I am writing regarding your consultation response dated 17 March 2026 for the proposed residential development in Shepley (planning ref: 2025/92776).

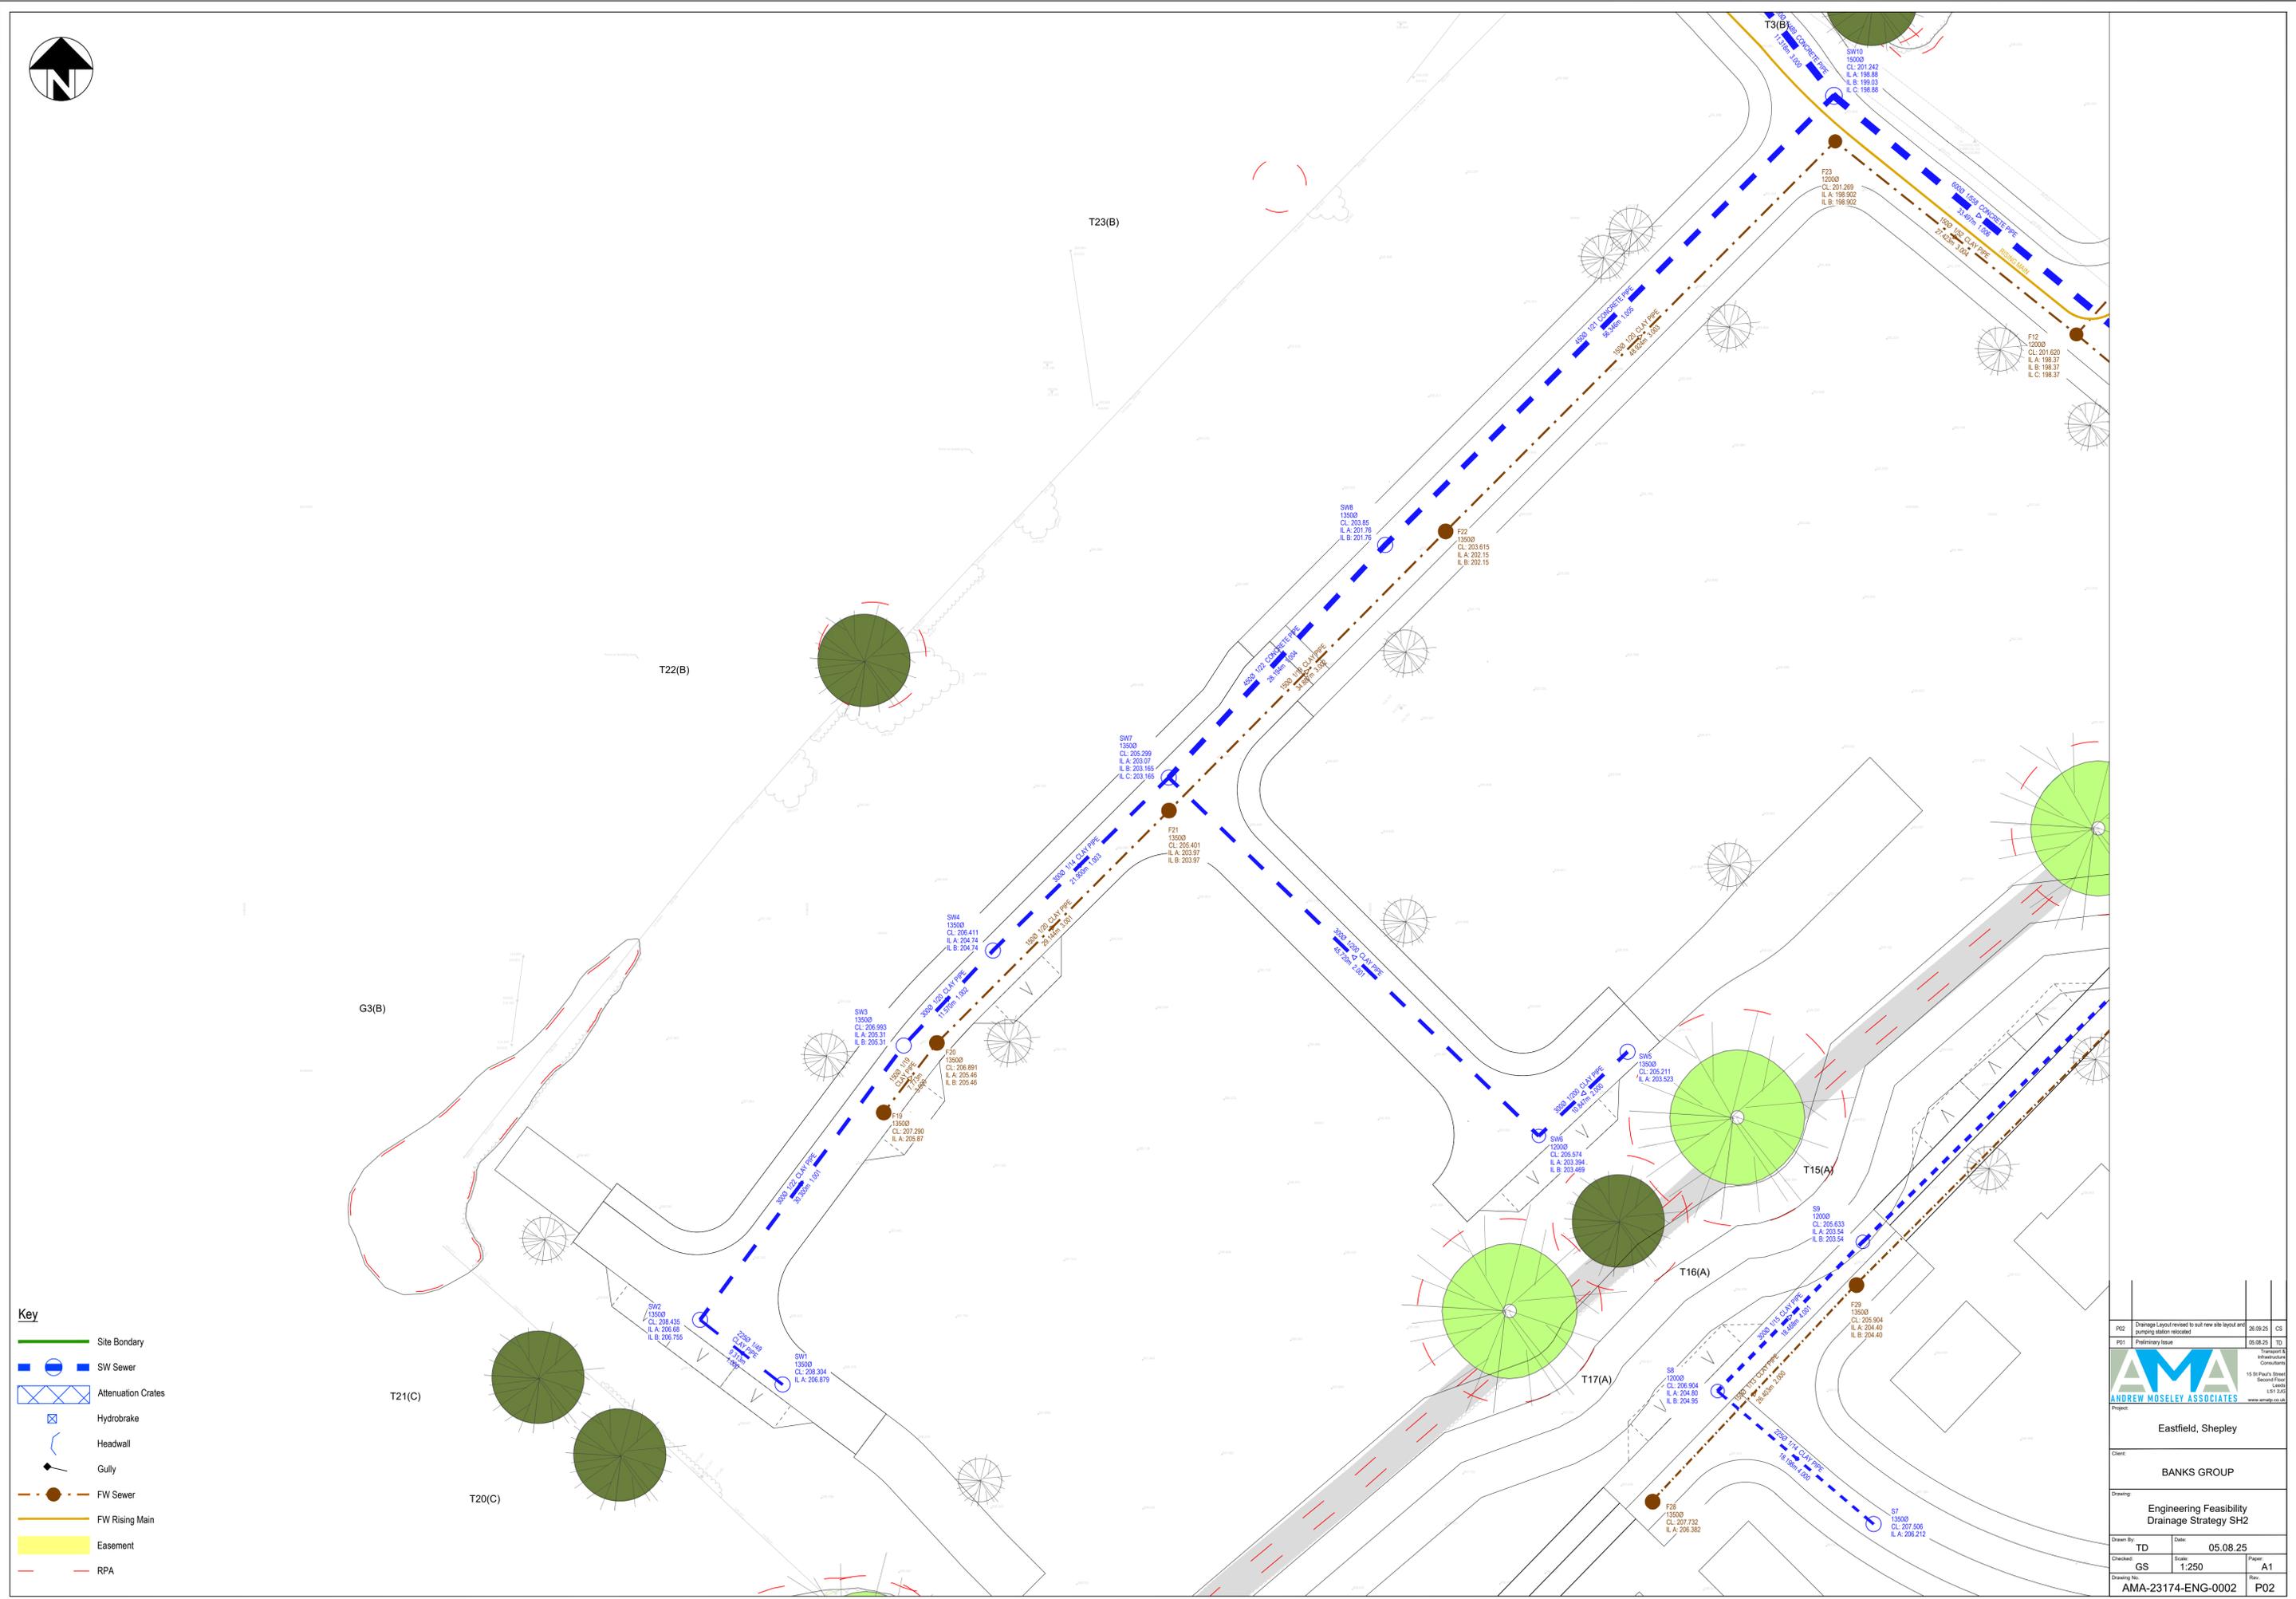
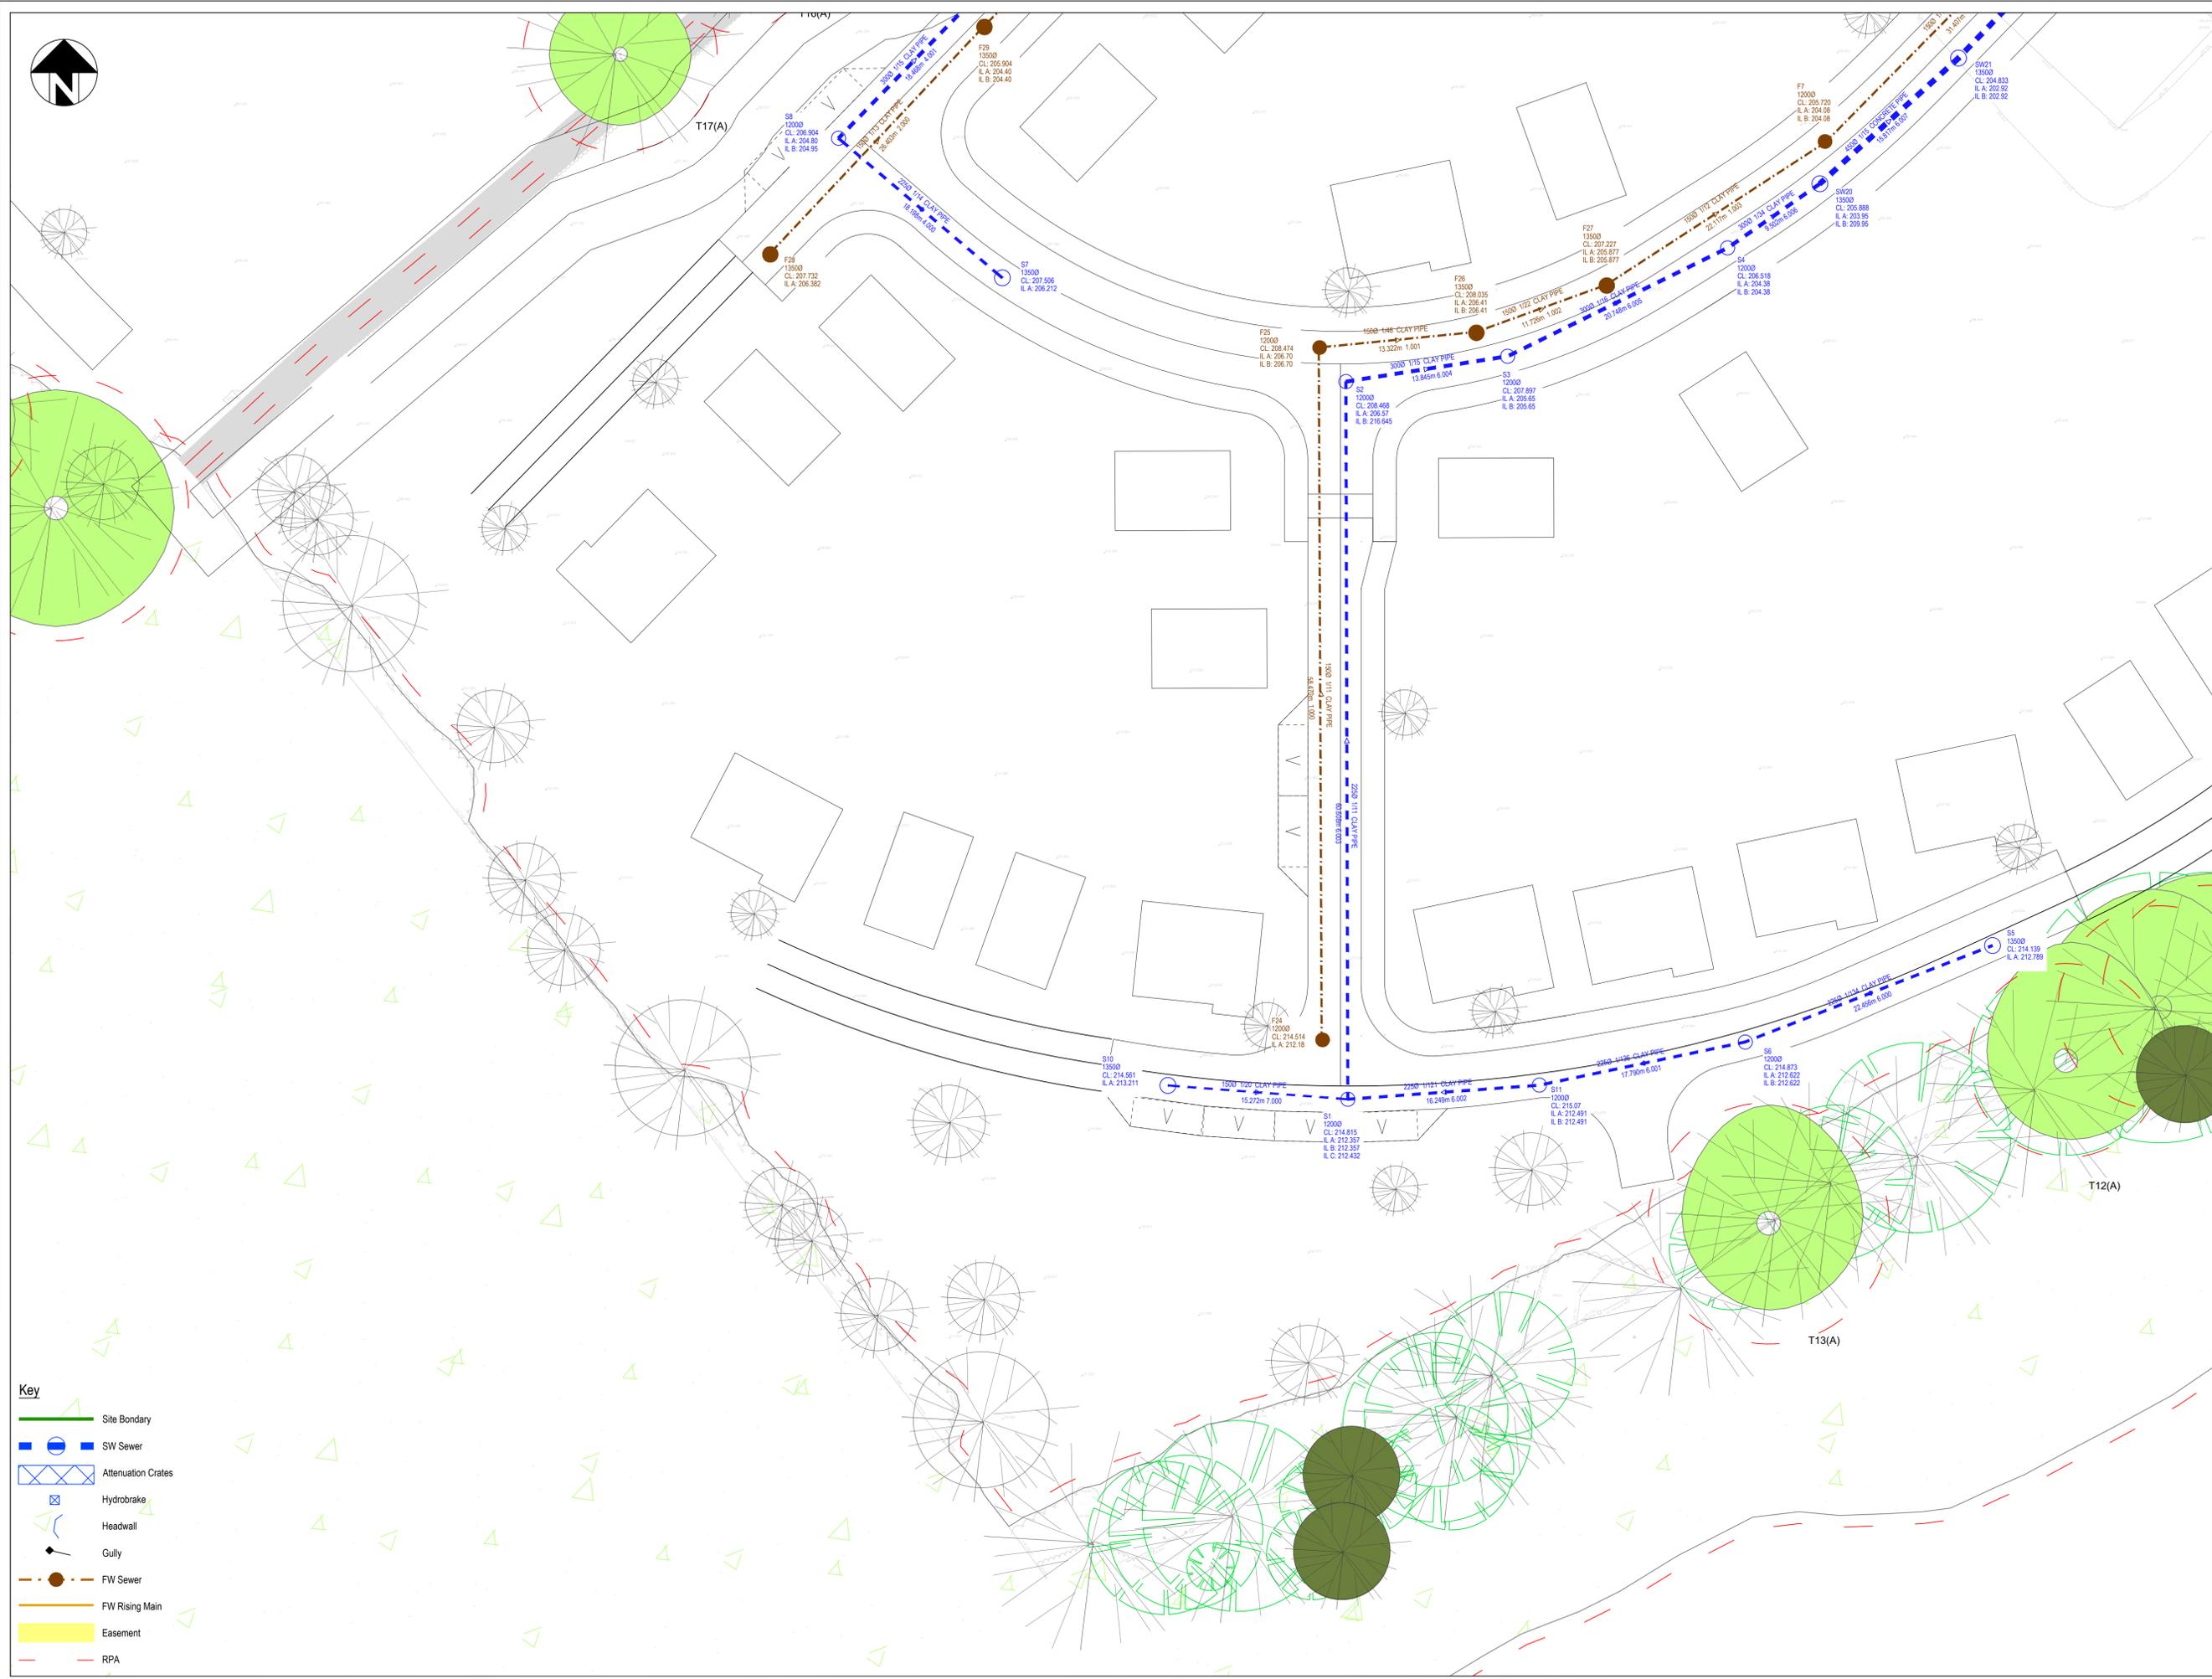
1. The site is partially located within Source Protection Zone 1 (SPZ1)
2. Proposed drainage infrastructure is located in close proximity to the Shepley Spring abstraction boreholes serving public drinking water supply
3. The site comprises a sloping field, increasing the potential for rapid surface runoff and pollutant transport
4. The scale of development (c.130 dwellings) will involve significant ground disturbance and construction activity

Given the proximity of drainage infrastructure to the abstraction point, I would be grateful if you could confirm whether these factors have been considered within your response, or whether further site-specific hydrogeological assessment would typically be expected prior to determination.

Figure 4 – DEFRA magic map showing Source Protection Zones around Shepley. A small part of the northern end of the site is within Source Protection Zone 1.

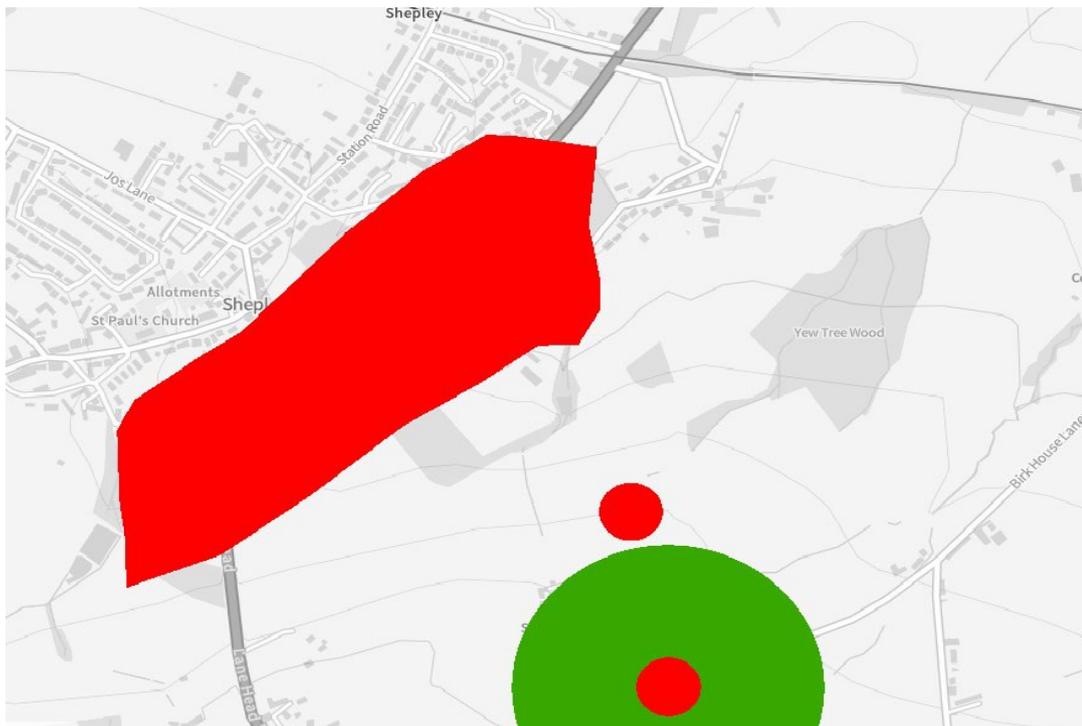
I would be concerned if the sensitivity of the SPZ1 designation and proximity to the abstraction point have not been fully assessed at this stage.
